An
Coimisiún
Pleanála

Technical Note- Ecology R323606_TN

Development	67 no. housing units on a site at Tyrells Land, situated along Stradbally Road, Portlaoise, Co Laois. Applicant is Laoise County Council.
Topic	Inspector request for specialist ecologist assistance regarding the NIS, supporting documentation, consultation responses and further actions.
Inspectorate Ecologist	Paula Kearney, BSc, CEcol, MCIEEM

Figure 1-2 Site Layout

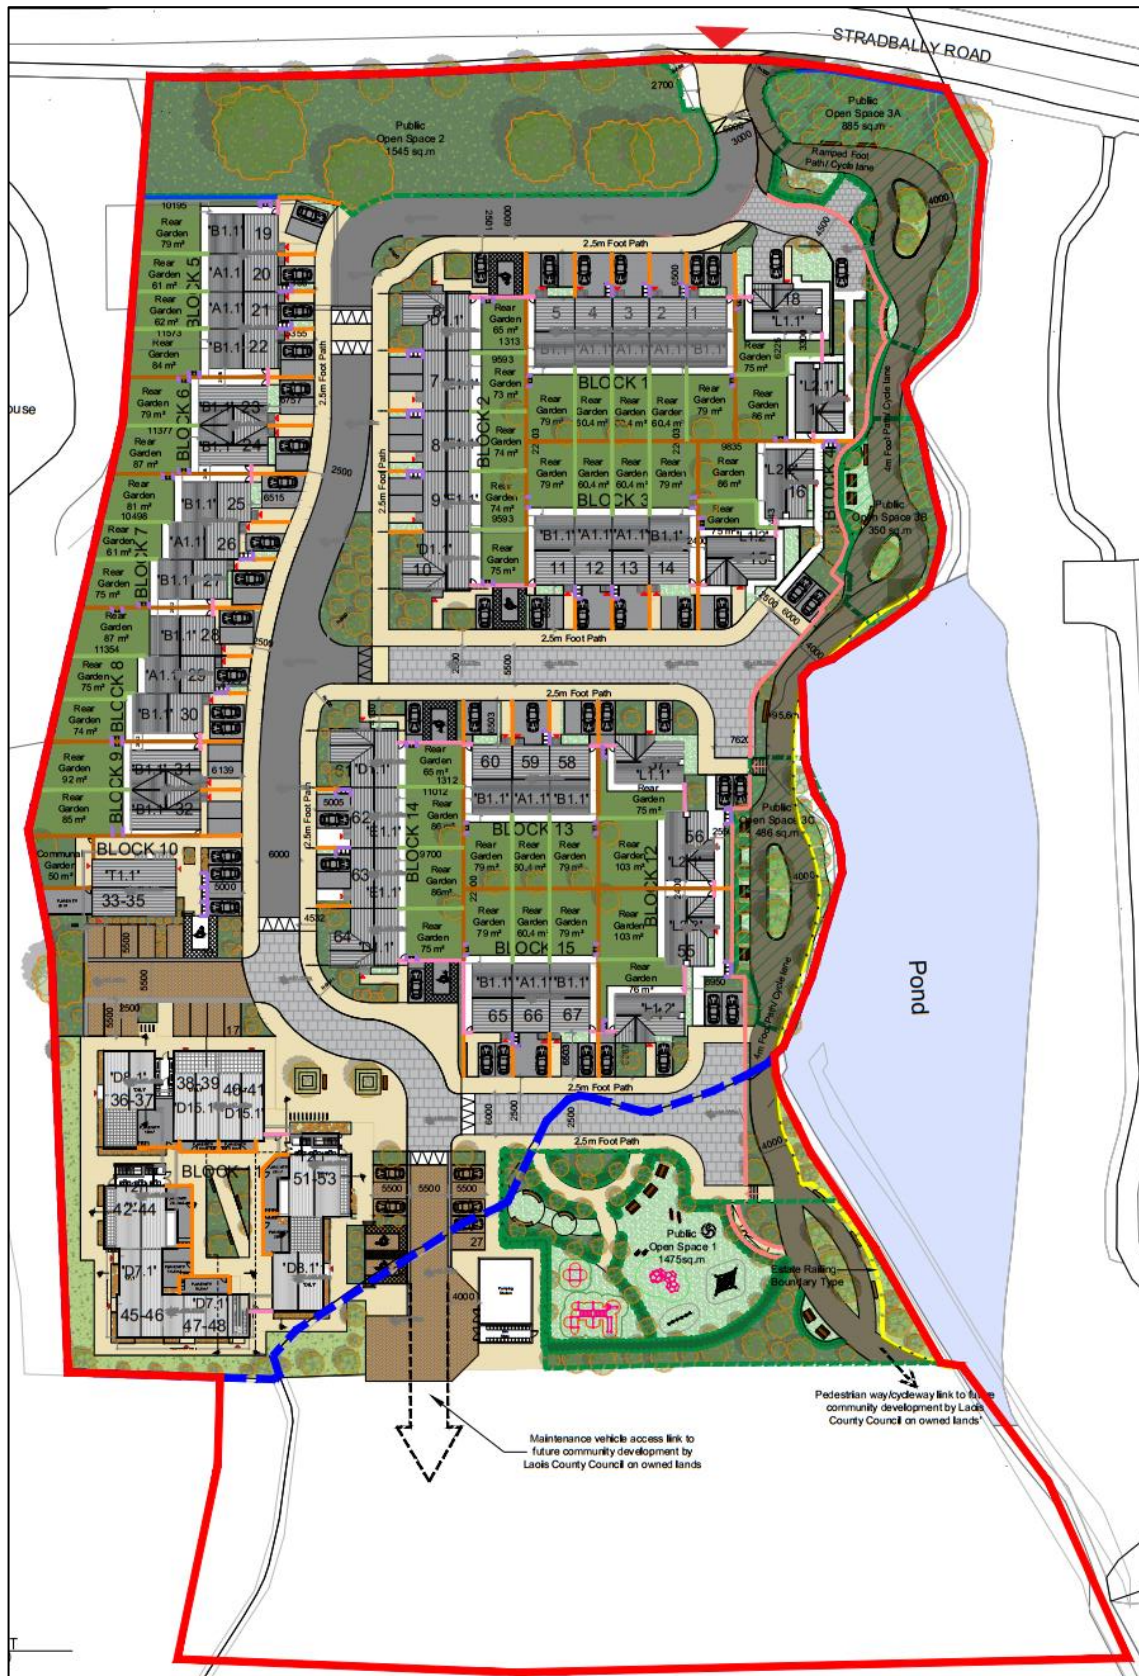
- 2.1.14. My main concerns relate to the proposed culverting and re-alignment of the drainage channel, namely the Maryborough Stream. Stream culverting and diversions are inherently complex, high-risk interventions that can alter hydrology, reduce habitat quality and continuity, and affect water quality through changes in sediment transport and flow regime. These activities require detailed ecological surveys, hydromorphological assessment, and site-specific mitigation measures, method statements and engineering design to ensure that the ecological functioning of the watercourse is maintained. In the absence of this information, the potential for downstream impacts, particularly in relation to hydrology, water quality and aquatic species cannot be effectively assessed.

- 2.1.20. Although the proposed works are a significant distance from European sites (13.2km) downstream I am not satisfied that there has been adequate survey or consideration of the ecological and hydrological baseline of the Maryborough Stream and proposed realignment in the NIS. Based on the documentation submitted, I am of the view that insufficient information has been provided to inform Stage 2 Appropriate Assessment.

- 3.2.2. Please submit a comprehensive watercourse diversion plan, following best practice guidelines and in consultation with relevant agencies, to include detailed, integrated documentation covering ecological and hydromorphological assessment, detailed engineering drawings, programme of works and actionable method statements.

Figure 4-4 Predicted Flood Depths at Existing Site [1,000- year MRFS]

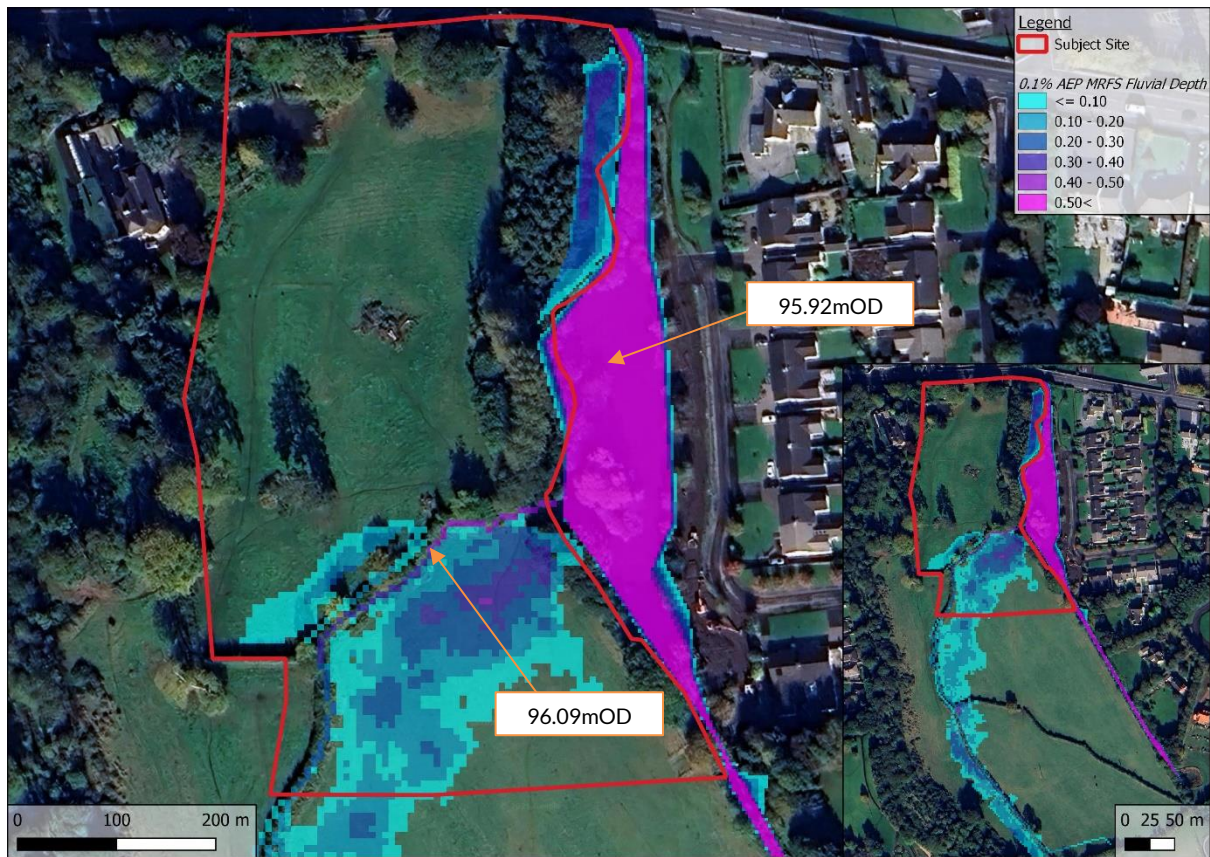
however, to fully understand the extent of flooding at the subject site and the impact of the proposed development, a site-specific hydraulic model was prepared for the subject site. The site-specific hydraulic model shows the areas liable to flooding during the 1 in 1,000-year MRFS flood event, see Figure 4.4 from the Stage 3 Flood Risk Assessment below.

Figure 4-4 Predicted Flood Depths at Existing Site [1,000-year MRFS]

- 2.1.16. Given the development proposes to raise ground levels at the southern and eastern ends of the subject site, adjacent to the Maryborough Stream and Derry Watercourse, it is estimated that approximately 376.1m³ of compensation storage will be required at the subject site to ensure no impact to flood risk elsewhere. It is proposed that 400m³ of compensatory storage is to be provided to the south of the realigned Maryborough Stream, shown in Drawing C-002 PL5.
